# SHORT STOP DEVELOPMENT PLAN MINOR AMMENDMENT

5819 PALMER PARK BLVD.  
COLORADO SPRINGS, COLORADO 80915

Add PCD File No. PPR1847

1 DETAIL SITE PLAN
 SCALE: 1:20

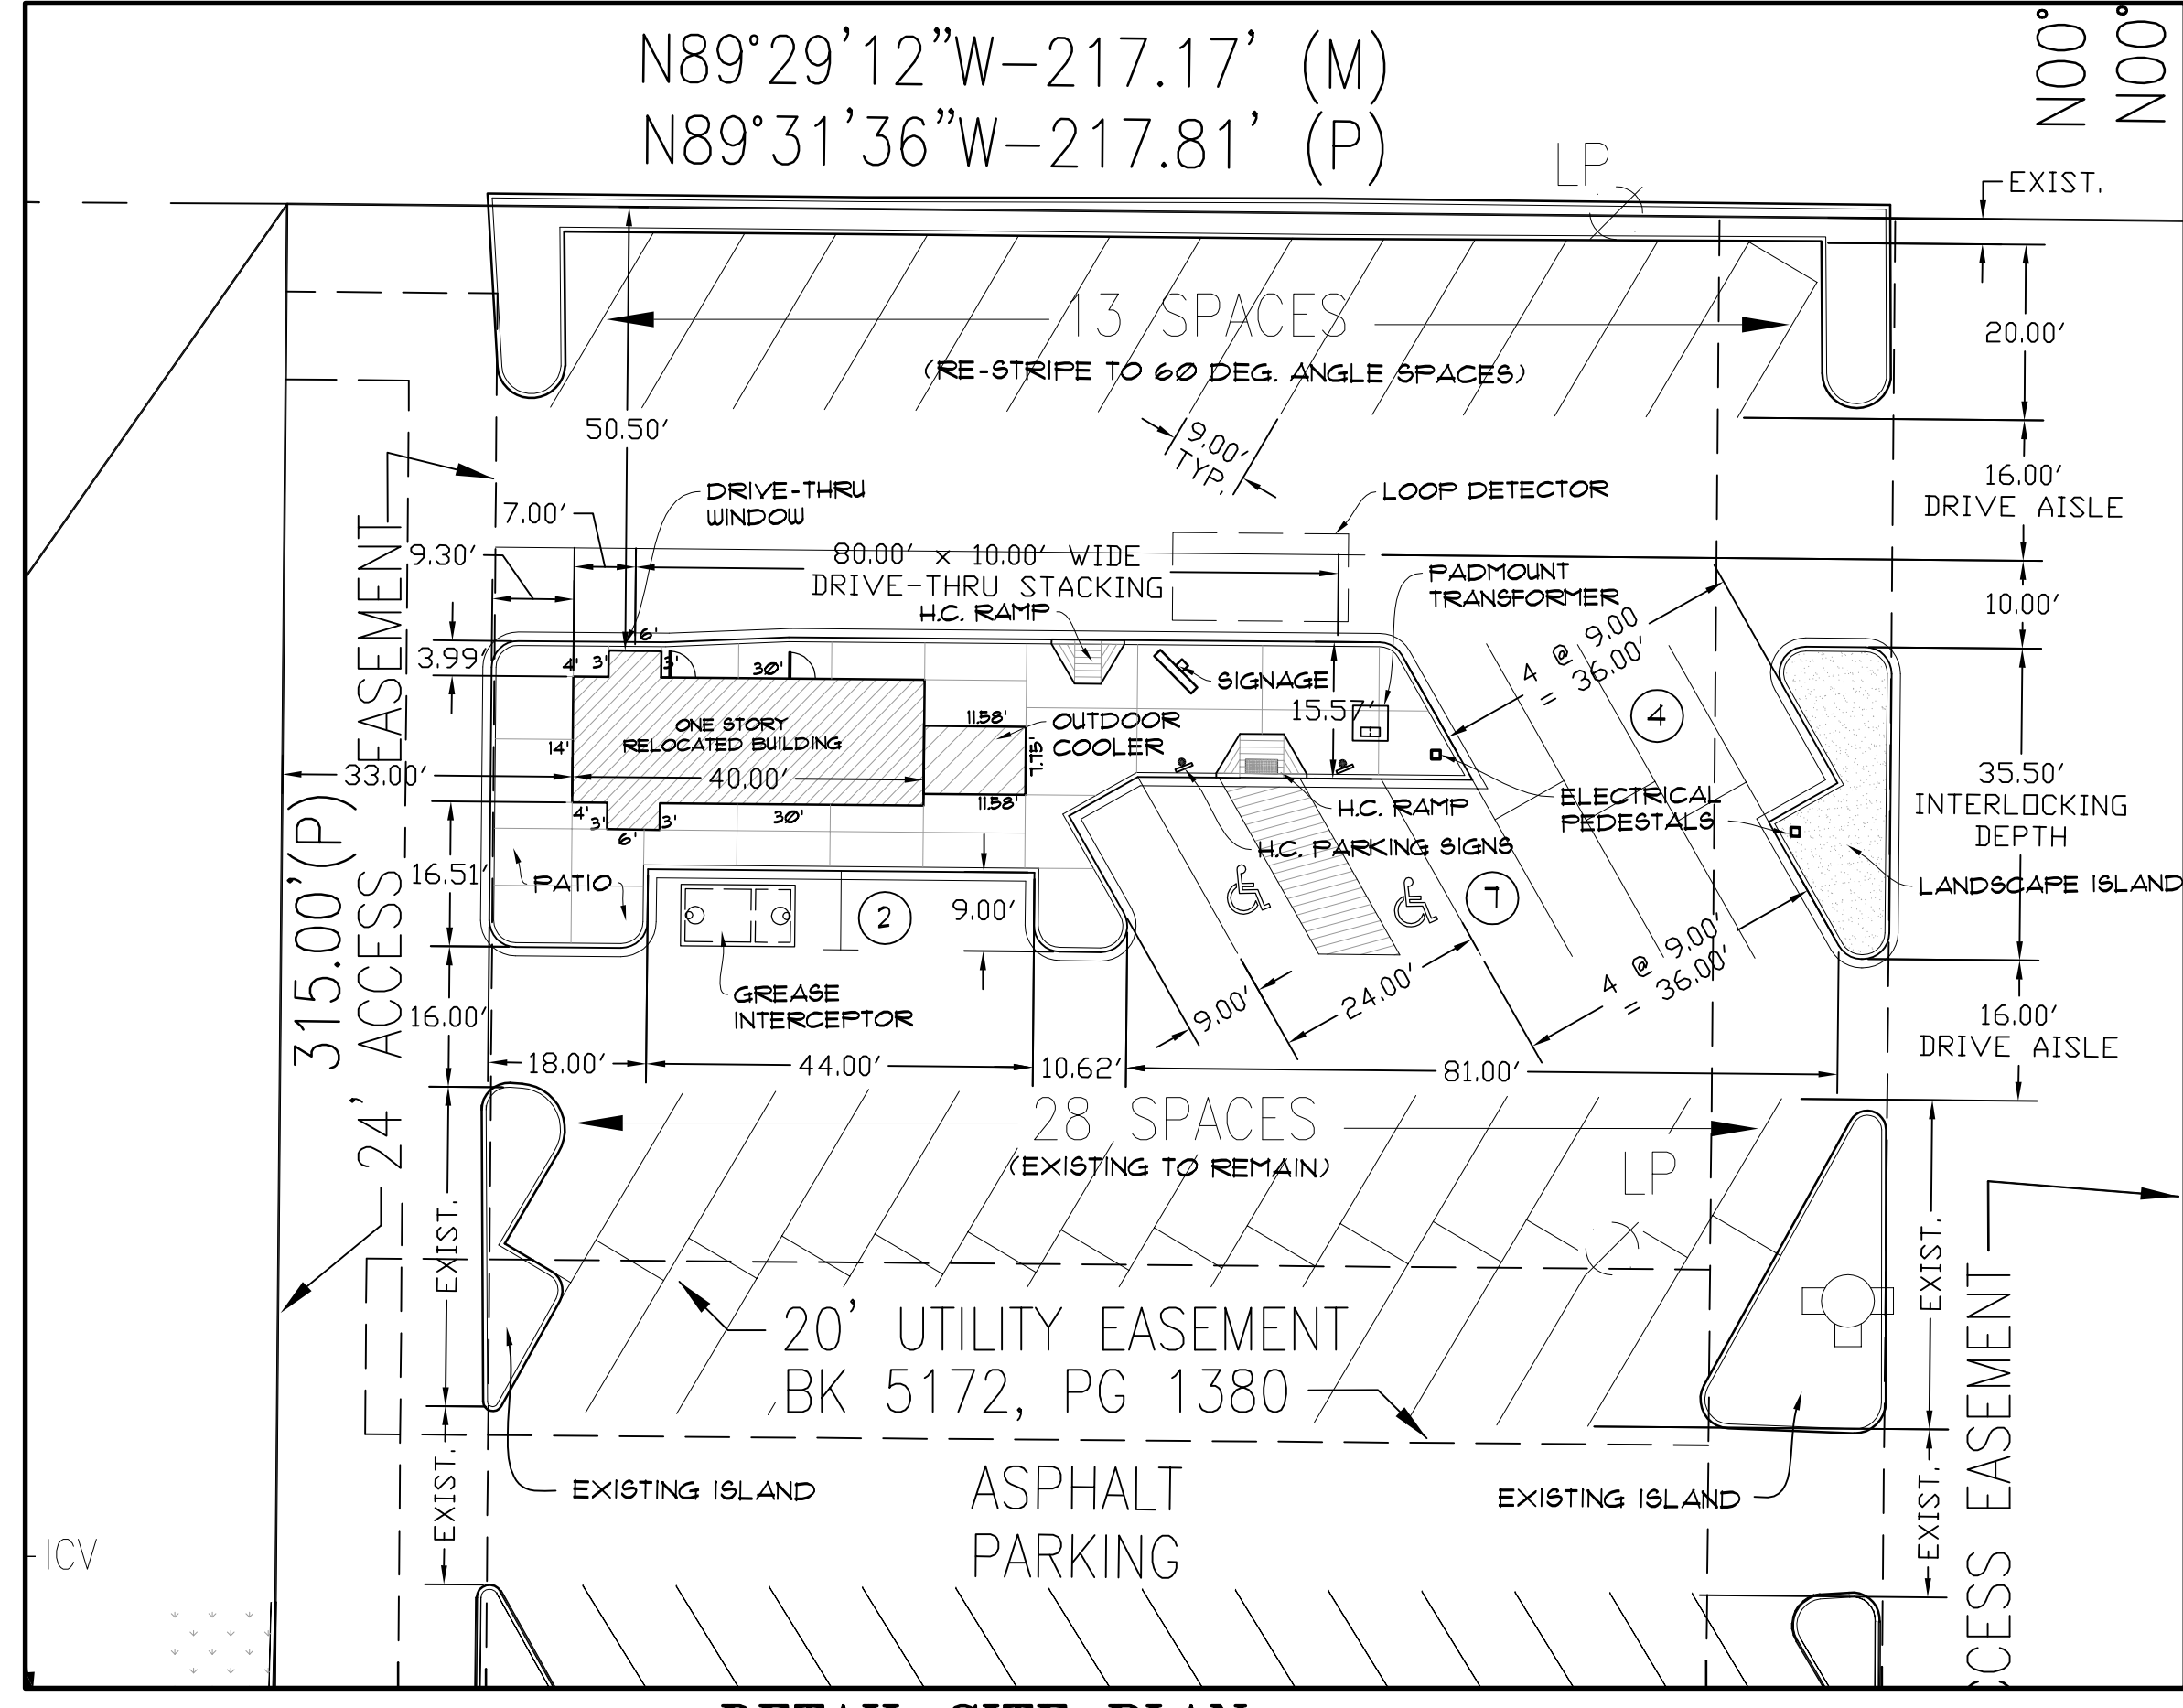
Label the proposed sand filter basin

Restaurants shall provide 90 feet of stacking behind each order board and pick-up window, or if the functions are separated, 30 feet behind an order board and 60 feet behind the pick-up window. The stacking may wrap around the building. -call out order board or show 90 feet of stacking.

Drive-through lanes shall be striped, marked or otherwise distinctly delineated.
